**Consultation Response from KC,  
Lead Local Flood Authority**

**2020/93779 Former Midlothian Garage, New Mill Road, Holmfirth, HD9 7LN**

**Discharge conditions 21-23 on previous permission 2015/93824 for outline application for  
erection of 56 dwellings and care home with associated car parking**

**Date Responded: 27<sup>th</sup>  
November 2020**

SHE-0200-2200-1500-2200
Hydro-Brake Optimum®

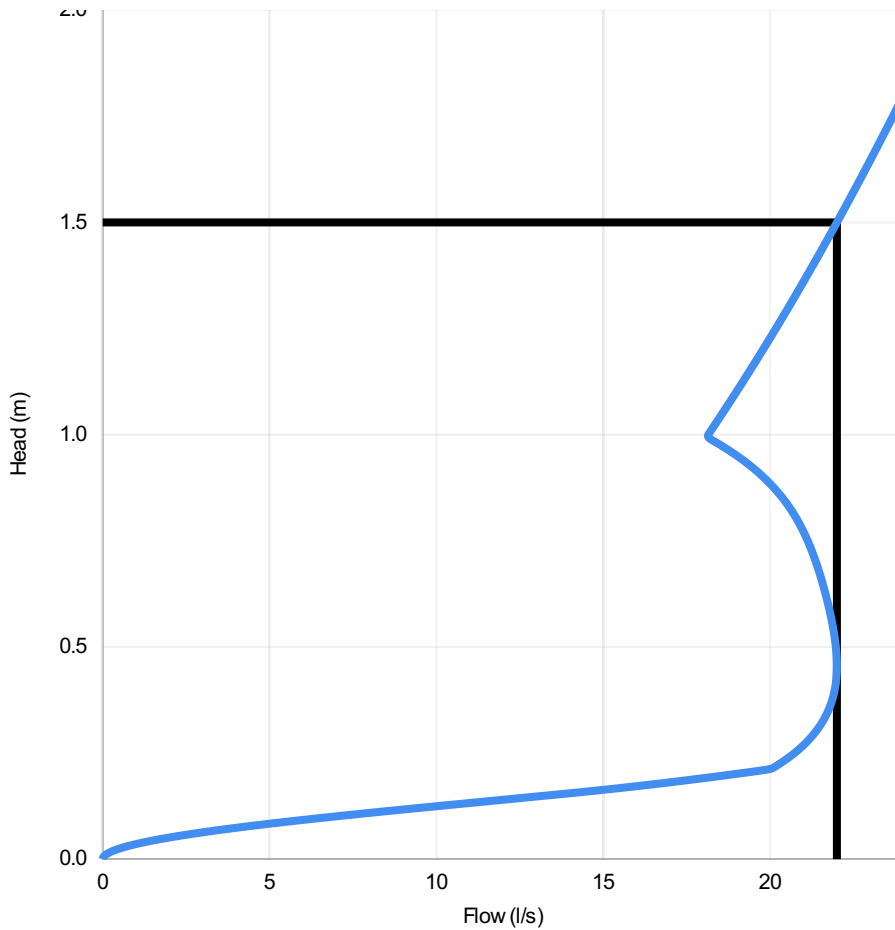
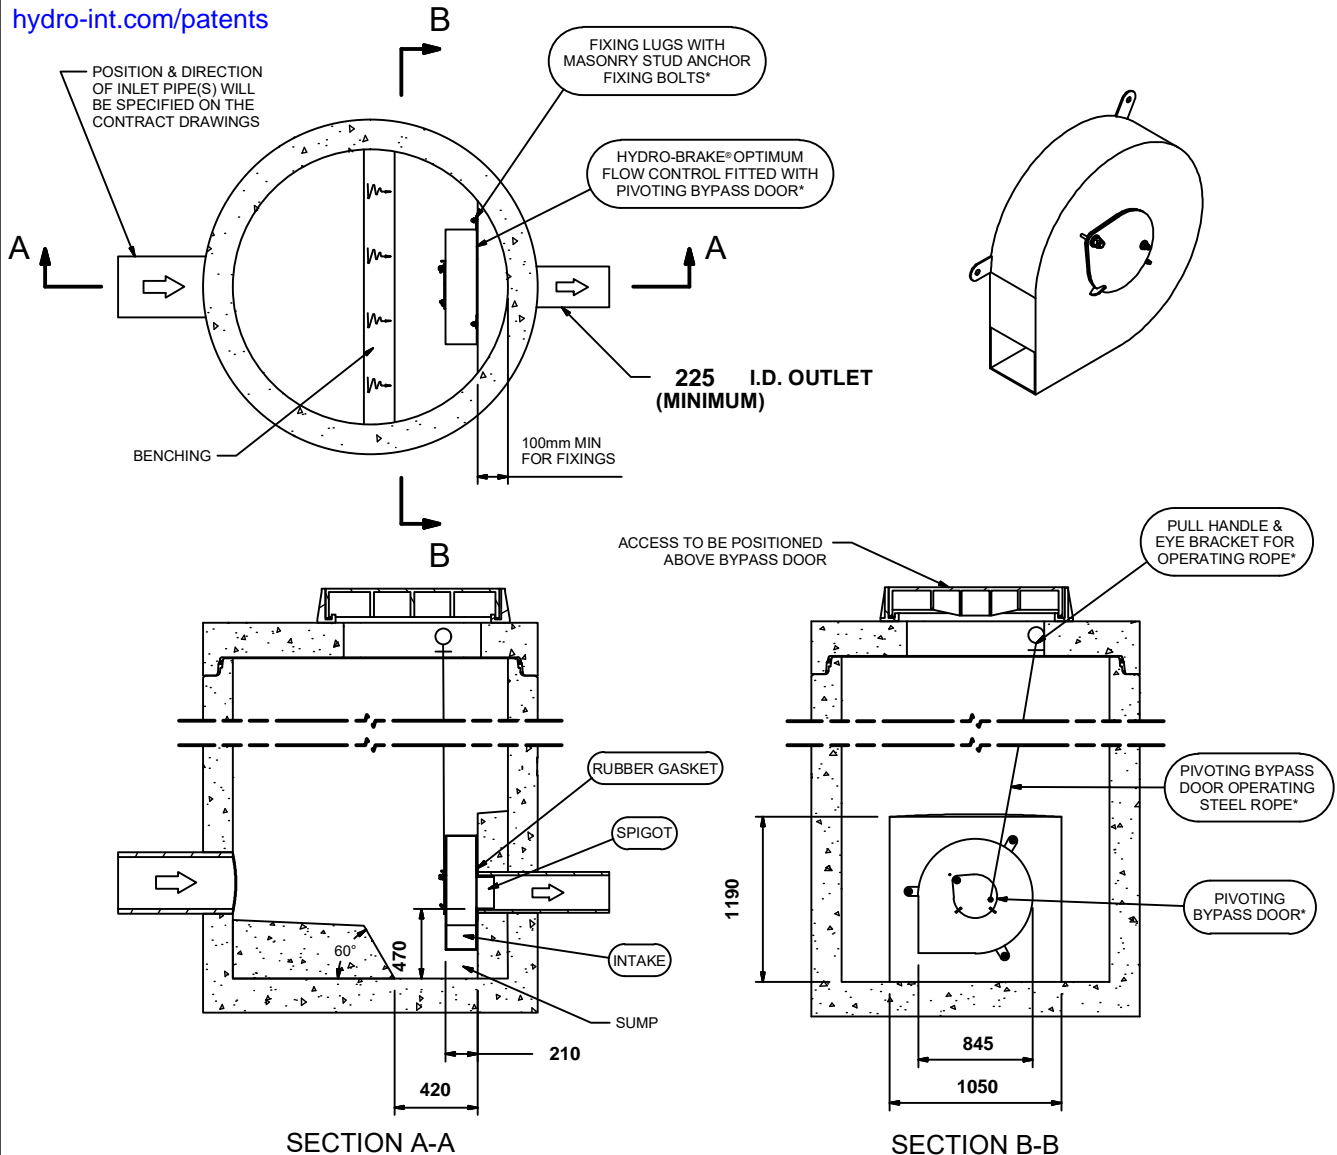
Drainage maintenance schedules must include replacement of neoprene seals for the flow control device as per manufacturer's requirements. Also, the testing of any emergency drain down on an annual basis with greasing mechanisms as required. The utilisation of a management company to maintain and manage surface water drainage on site up until the sewerage is adopted by Yorkshire Water and/or Kirklees Highways must be set up in a unilateral undertaking under section 106.

Drawing title: S104 LONGSECTIONS

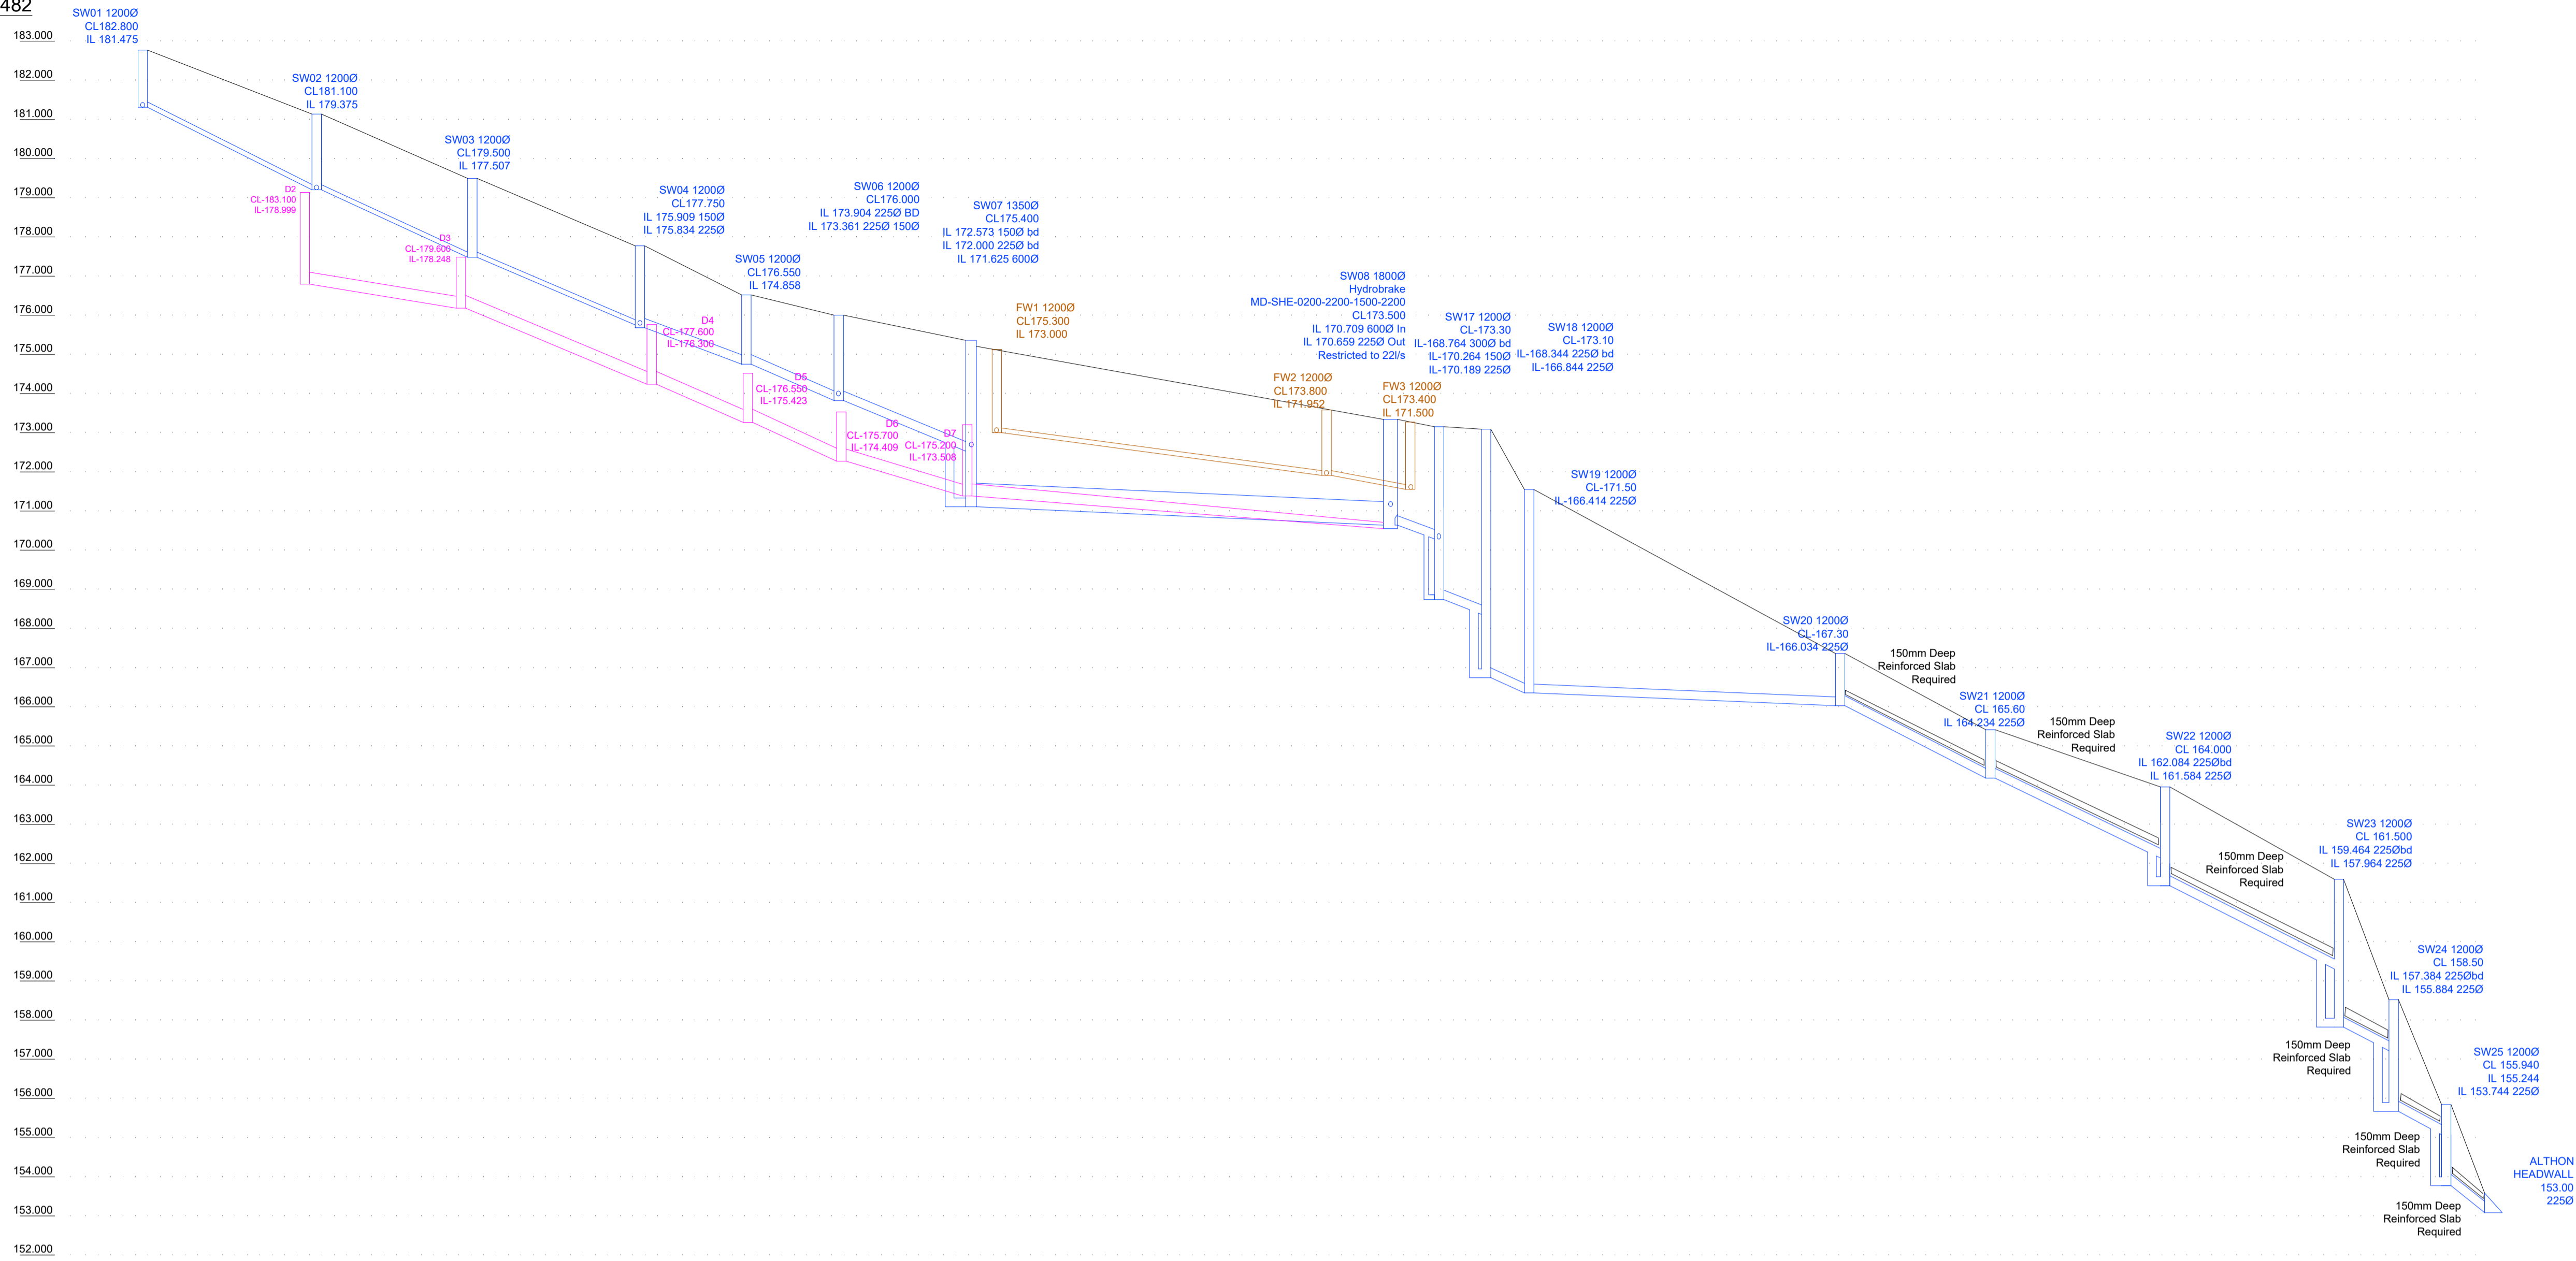
The off-site watercourse diversion needs to be demonstrated that there is a 5-metre avoidance of trees. We do not believe this is feasible and suggest the public right of way as a clearance is utilised as much as possible. This will need to be compliant with our PROW officers and we suggest the planning officer includes them in a discussion to find a solution. We also suggest a site visit to agree the route. This aspect should also be included in a long-term maintenance and management plan secured under section 106 unilateral undertakings.
